SUBJECT: Engineering Review Comment
Mountain View Electric Association Inc. (MVEA)

Project Name: Waterbury Filing 1 – Final Plat

Project Number: SF237

FINAL PLAT

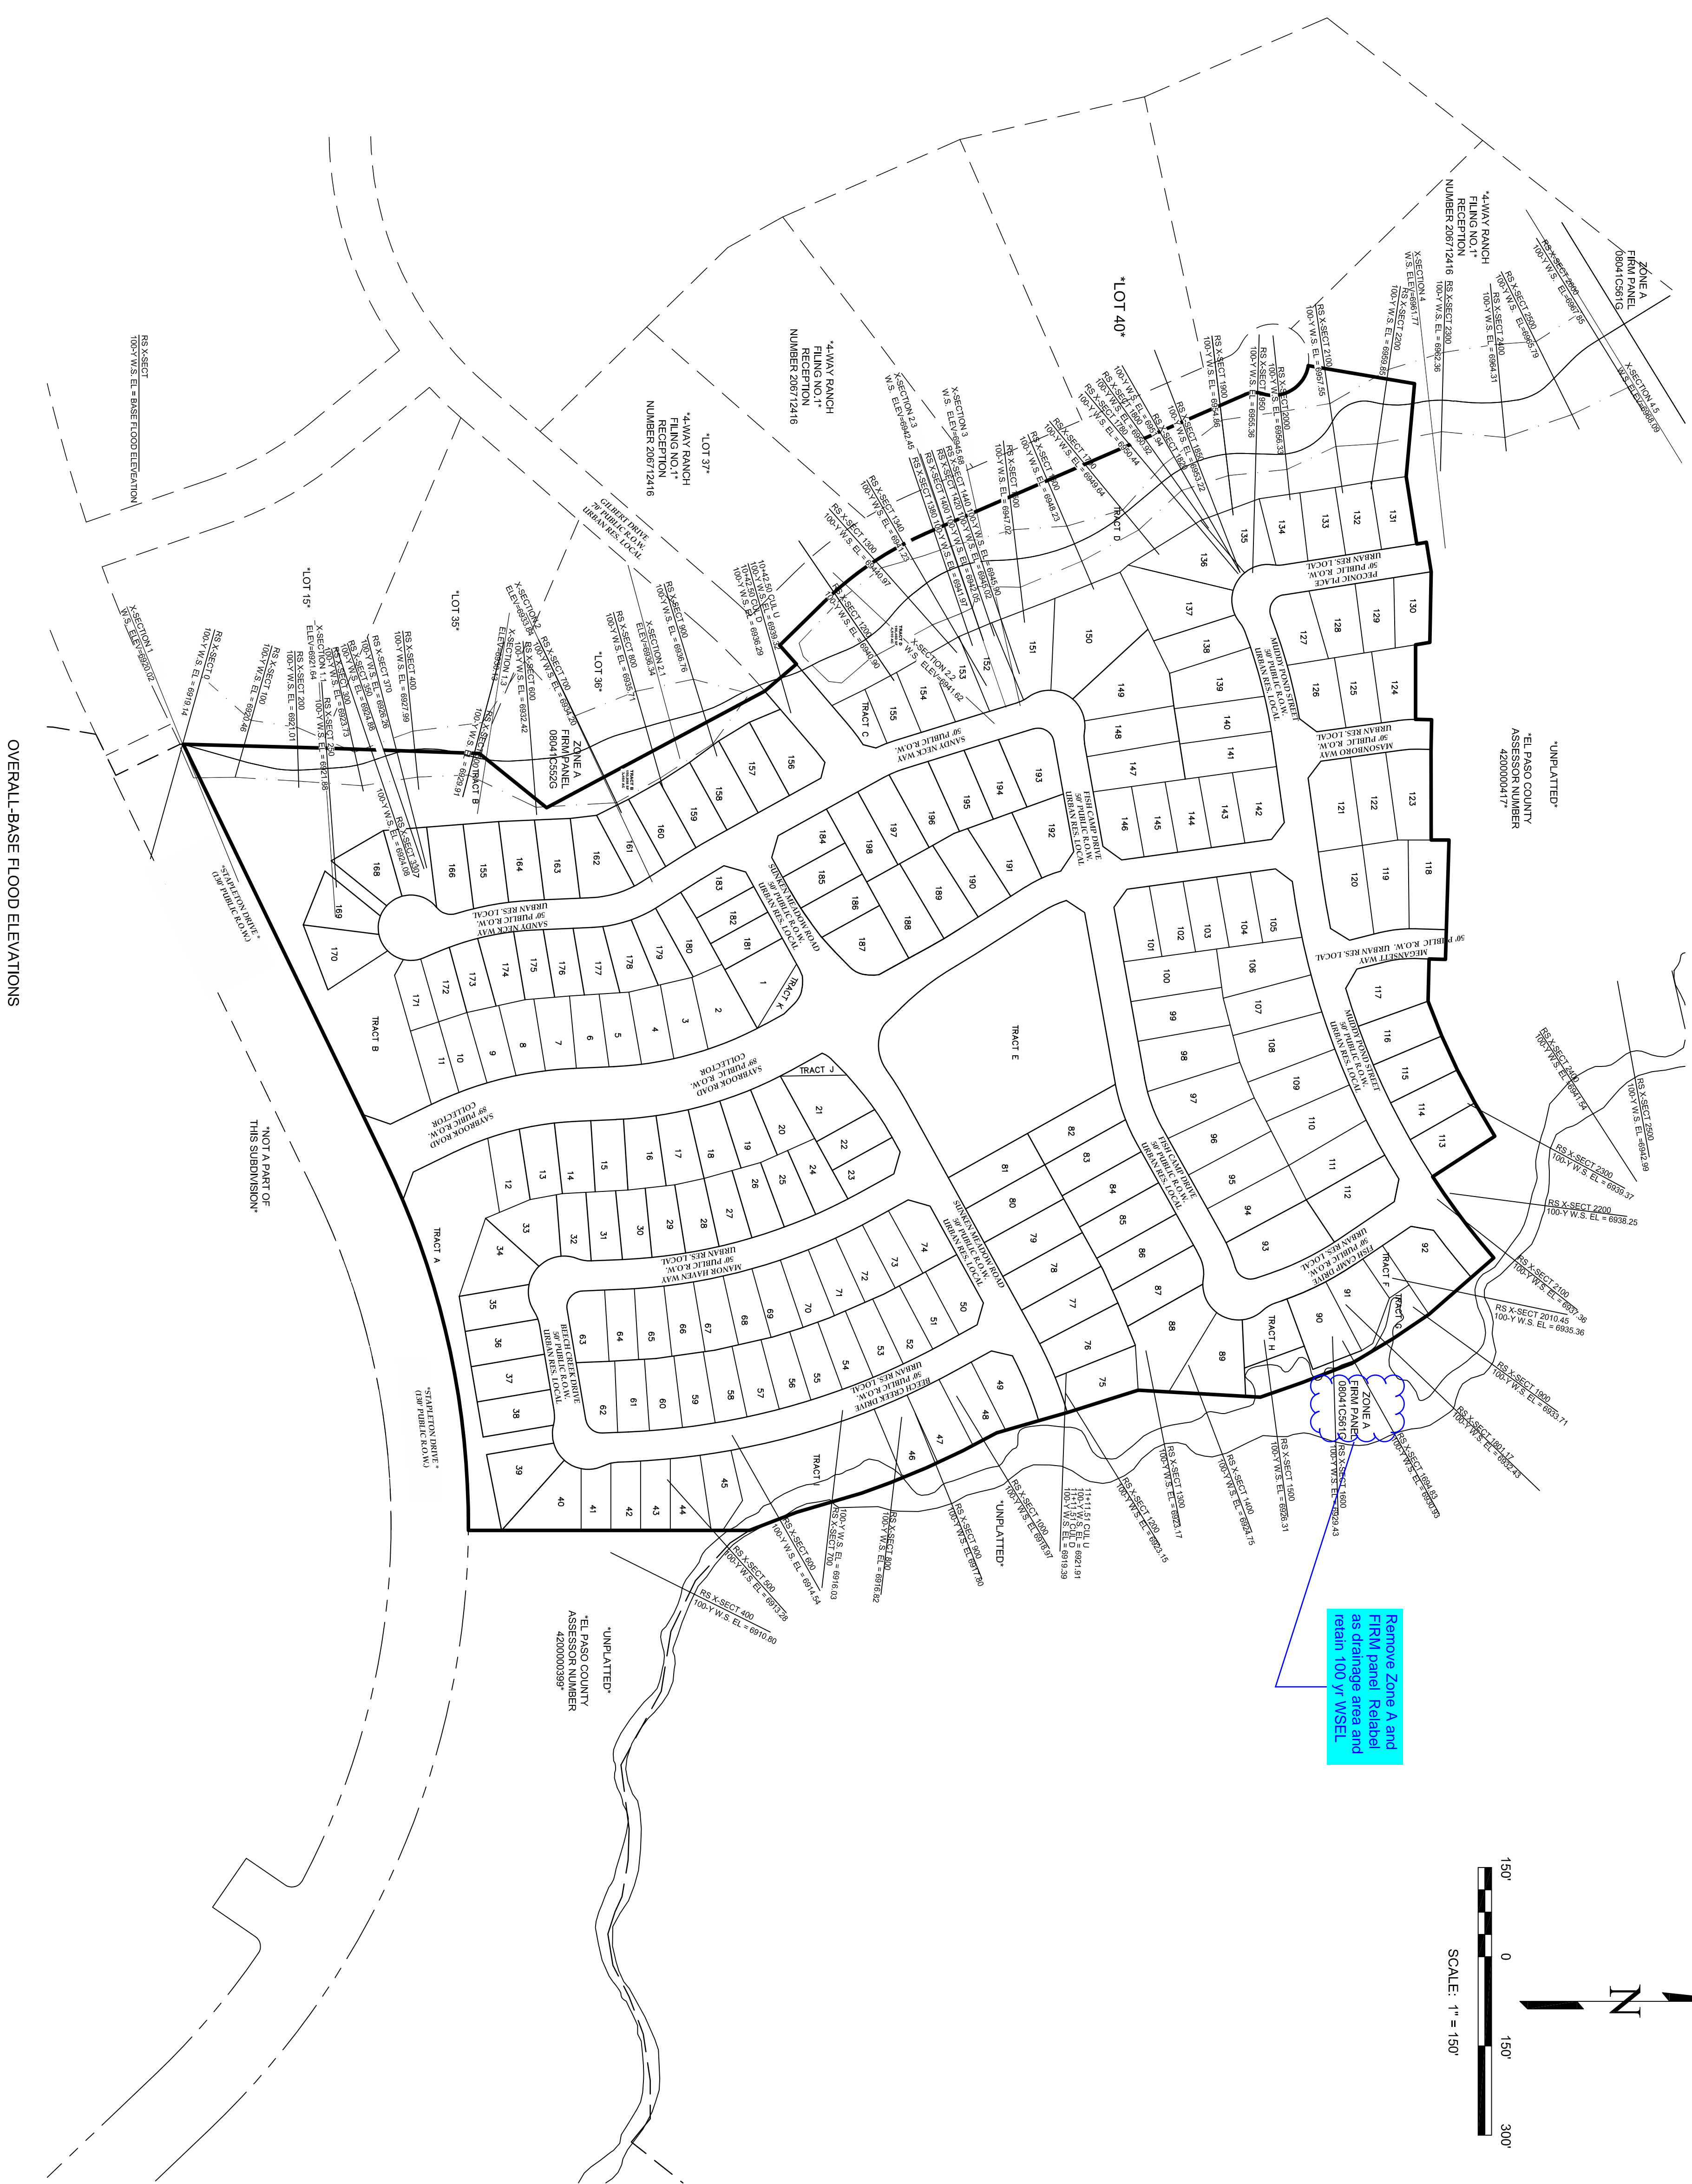
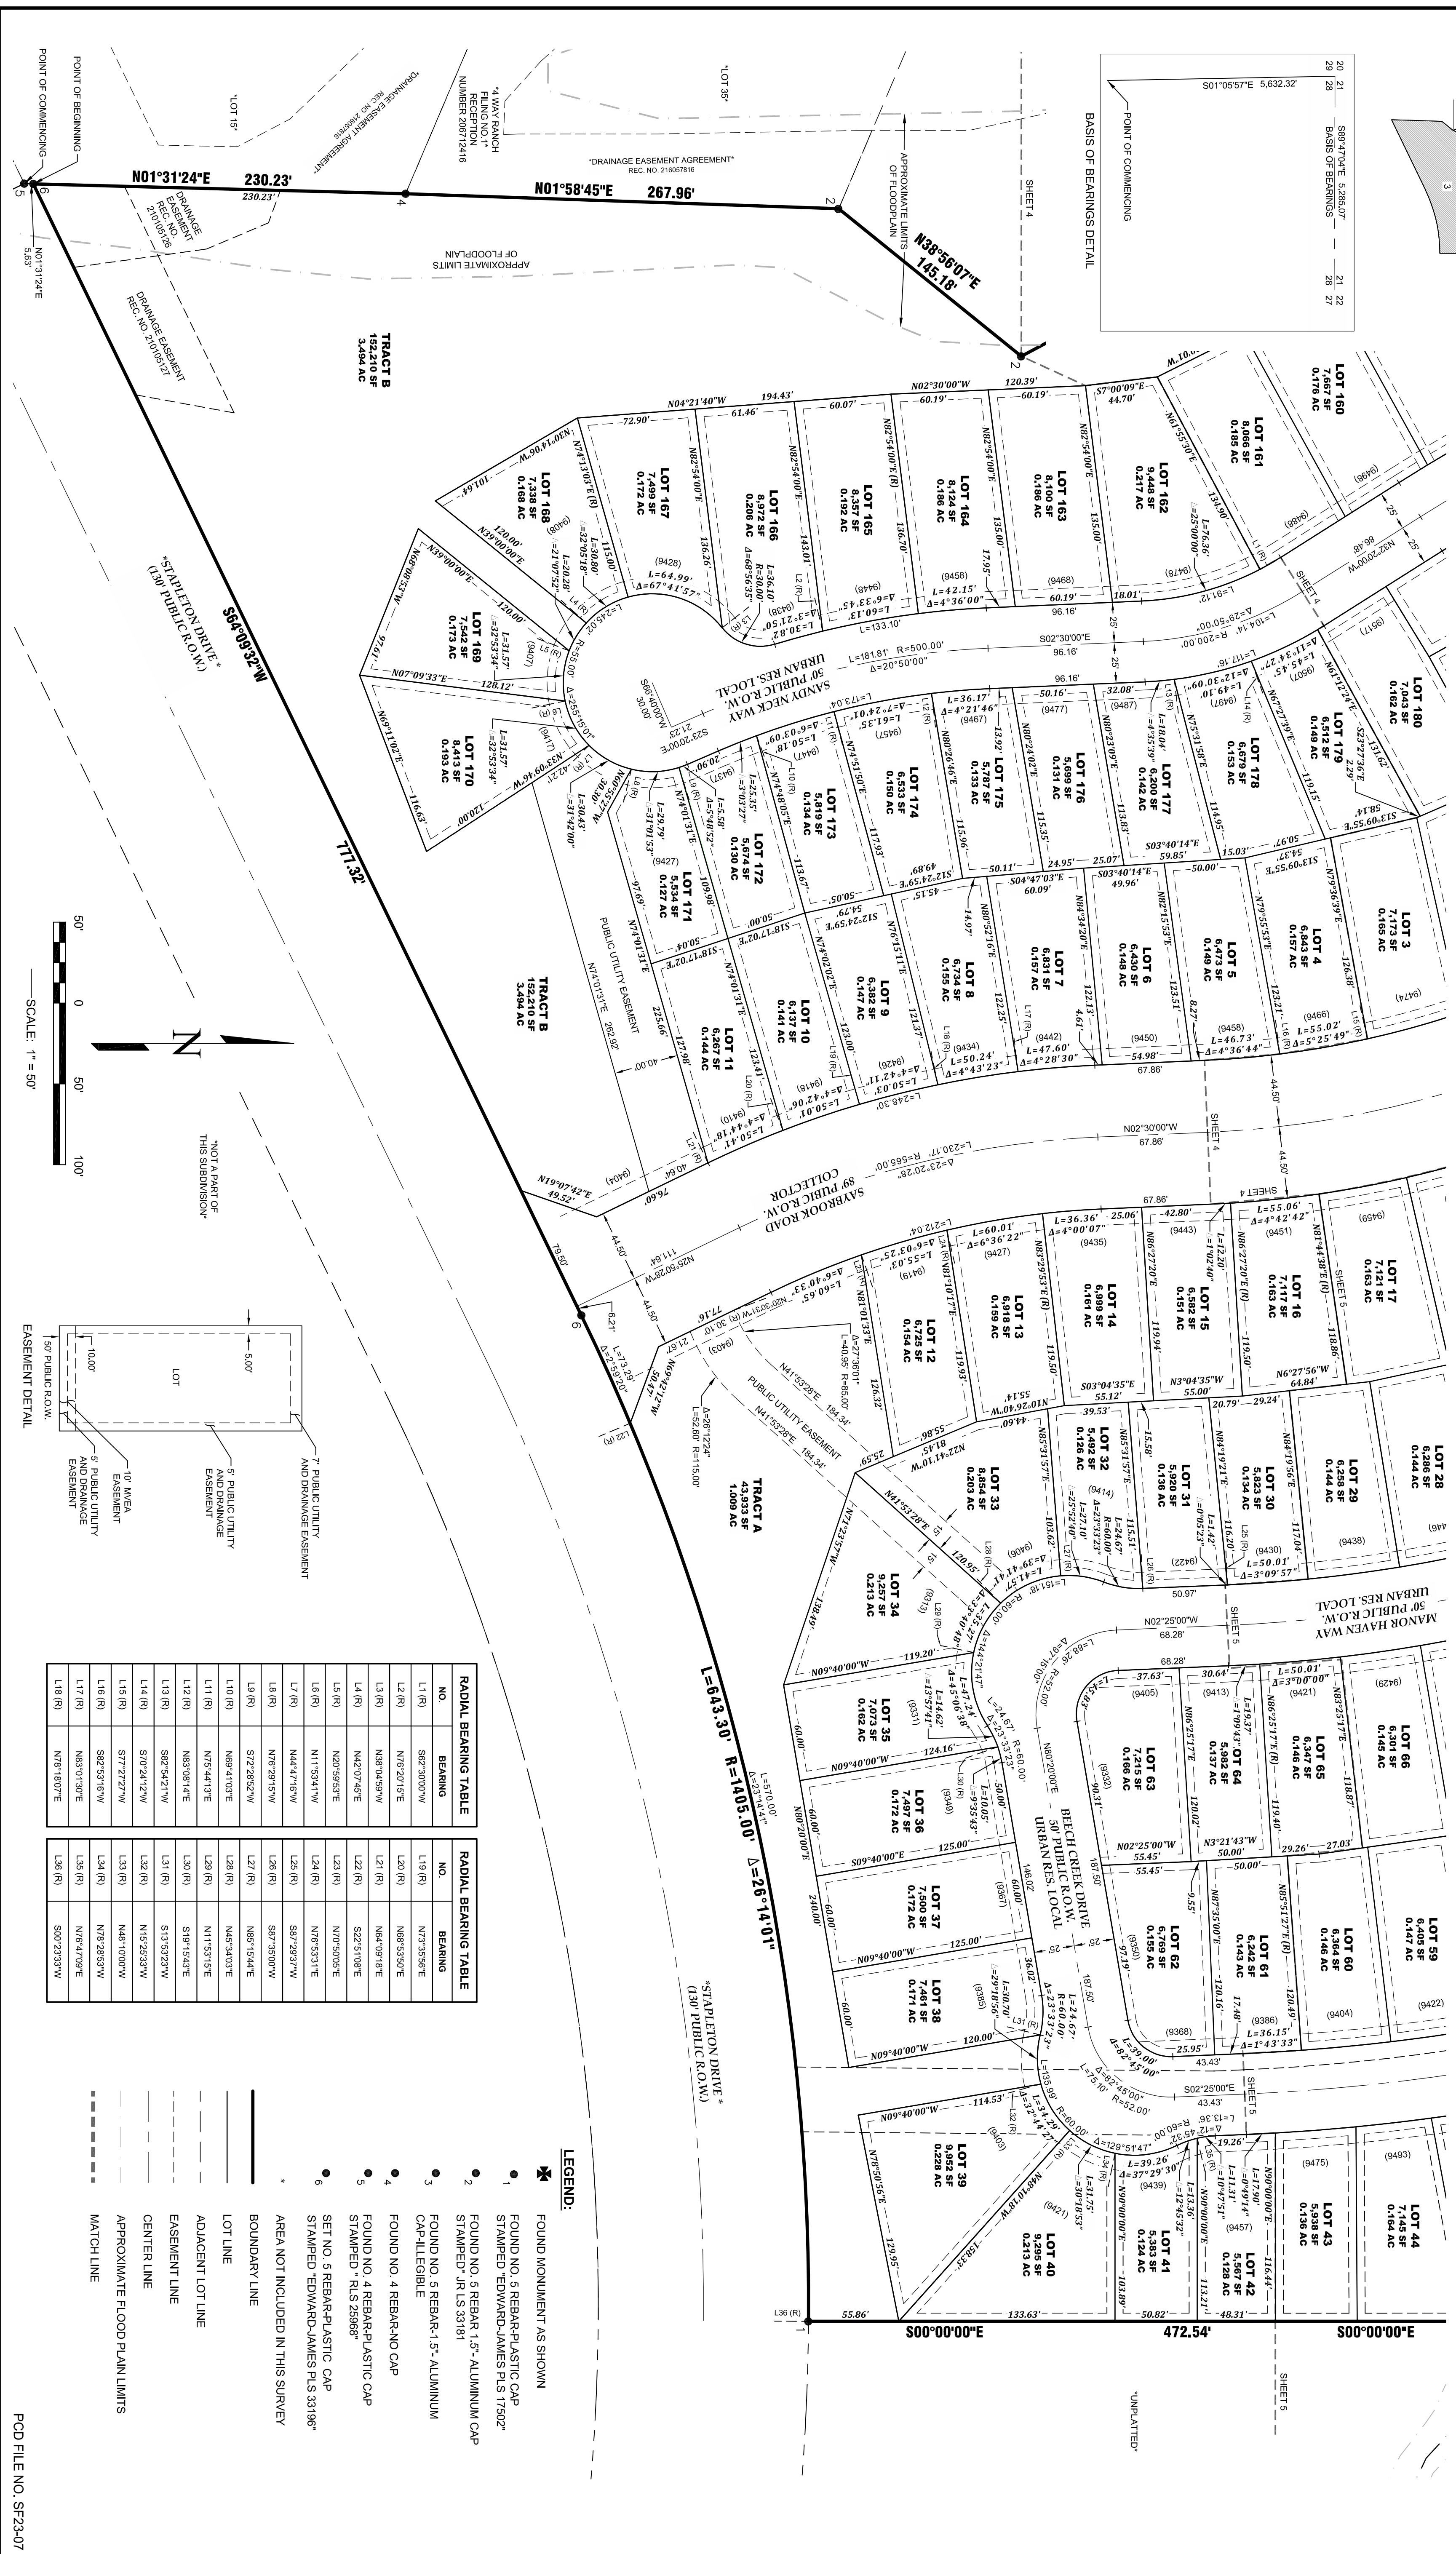
After review of the plat, MVEA is amendable to all the easements **except** MVEA requests a ten (10) foot front lot utility easement in addition to any public improvement easements and **all** tracts include easements. The Tract Table does not align with General Note #7 – Tract Ownership Maintenance. MVEA also requests the platting of MVEA's existing facilities with easements on the plat. Additional easements may be required.
